I have received the enclosed email from my constituent, Ms Susan Bunyan of Apartment 1 Esplanade Grande, The Esplanade, Bognor Regis, PO21 1NY, regarding her concerns about the planning application BR/194/17/PL.

ADC Planning Application BR/194/17/PL

As you may already be aware, the above planning application covers the building of a new beach office and a unisex toilet block on the site of the existing foreshore office on Bognor Regis promenade, directly opposite our Esplanade Grande residential building (51 apartments). Whereas the beach office is no cause of concern to our residents, the proposed new toilet block has led to intense anger and distress, for the following reasons.

DRAWING
Proposed Toilet Elevations

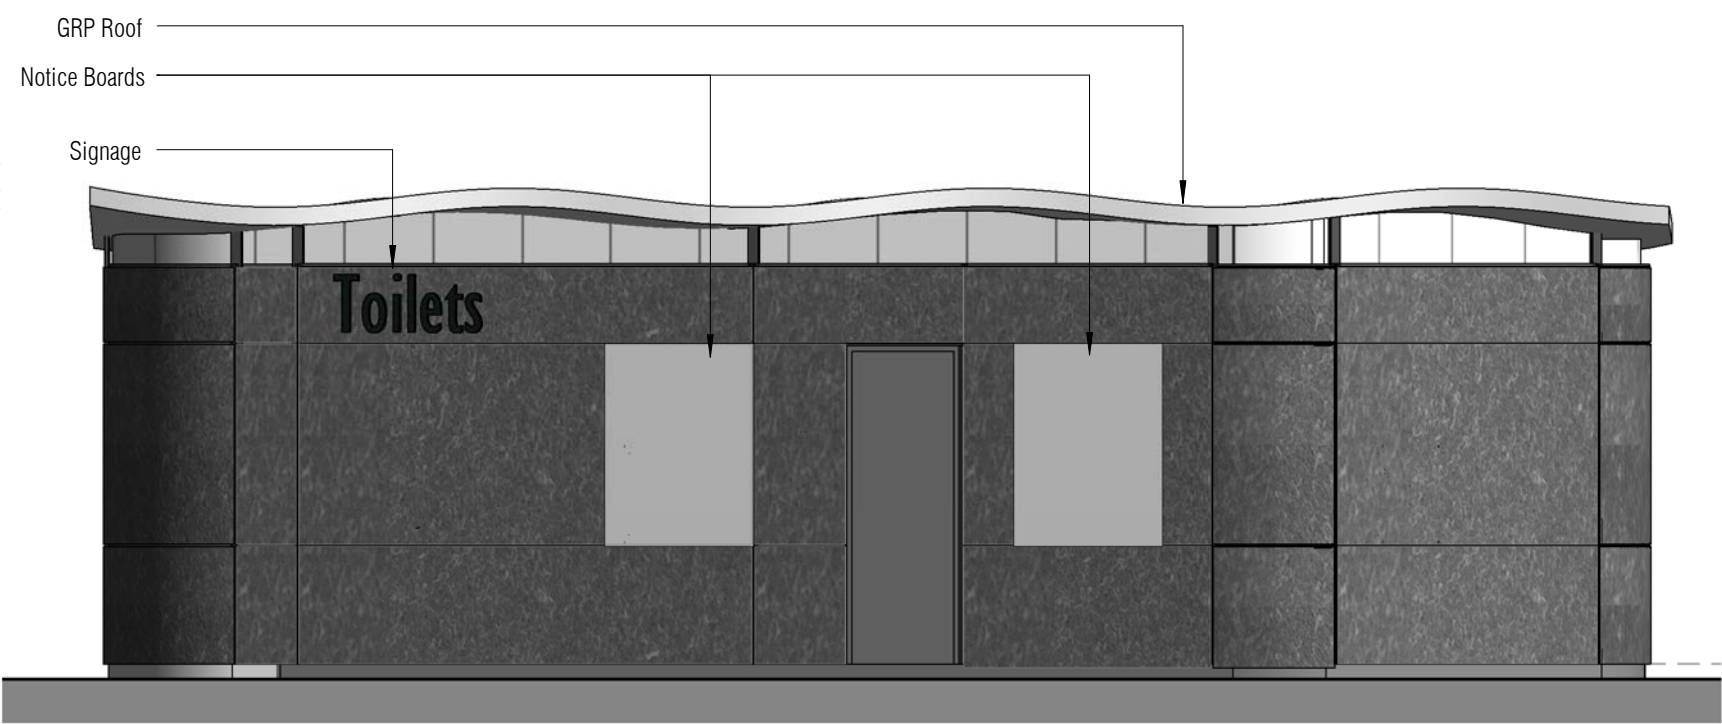
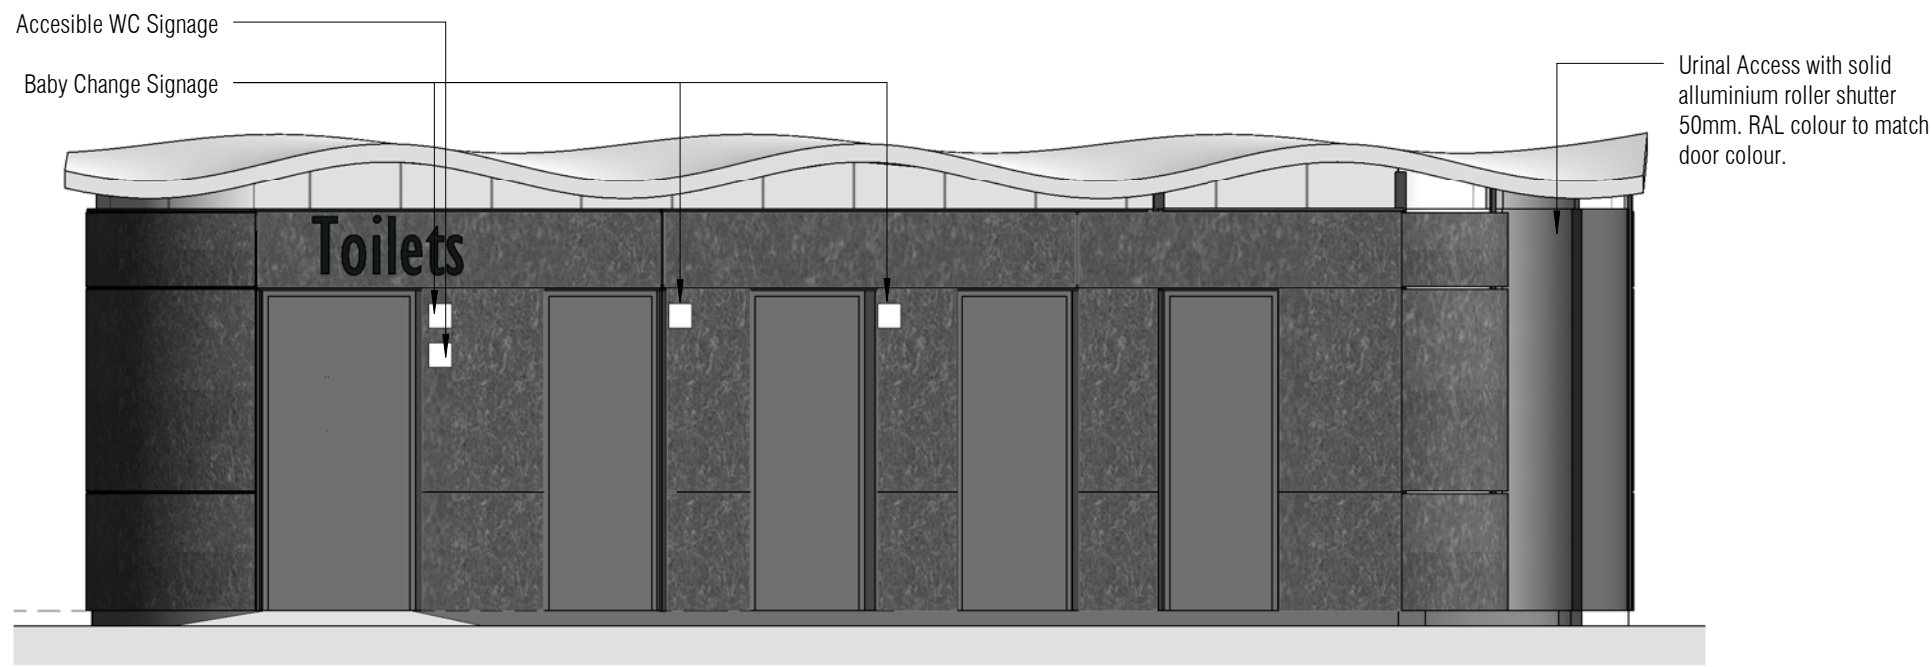
Toilet Door Position To have the cubicle doors on the north side is repugnant and unacceptable. To have toilet in/out/queuing activity in front of their eyes all day long would be absolutely disgusting and intolerable to residents in the building opposite. Such an orientation of the doors runs completely contrary to civilised values, to the point of vulgarity. It thereby does very substantial harm to the 'residential visual amenity' of our building (note: different from 'right to a view').

ii) Position the toilet cubicle doors on the south side.
